June 17, 2008

**RE: Gerard Preliminary Plat ( LP-08-12)**

GERARD PLAT
 PART OF SECTION 14, T. 18 N., R. 18 E., W.M.
 KITITAS COUNTY, WASHINGTON
 -- PRELIMINARY PLAT --

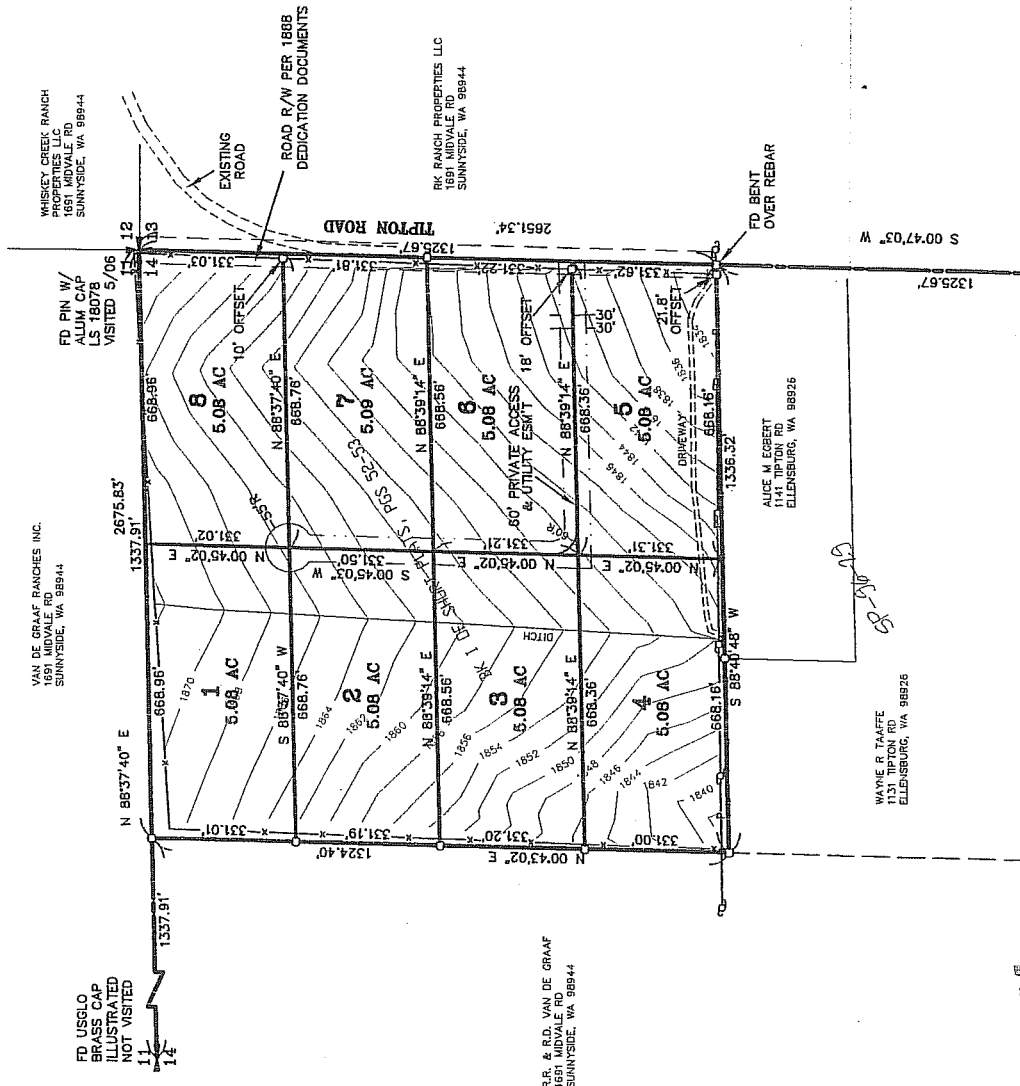
First of all after reading through the application several times I did not see any references to the protection of the KRD Ditch that runs through the proposed development. I get my irrigation water through this ditch and so do a lot of land owners below me. My understanding is that the development in question does not have any water rights to the water that flows through this ditch. At any rate we need a guarantee that the water in this ditch will not be diverted in any way and the land owners will work with the KRD to ensure compliance. Secondly I don't know what impact the (8) new wells and septic systems will have on my property or those around me so we need to be clear that any adverse issues regarding our wells (flow and clarity) will need to be guaranteed repaired to original status by Mr. Gerard and the new property owners. Thirdly my property is zoned AG 20 and I do not want this to change at the current time based on improvements going on around me. If the new property owners of the Gerard Plat can abide with all of this, then I view this as positive growth and will welcome my new neighbors
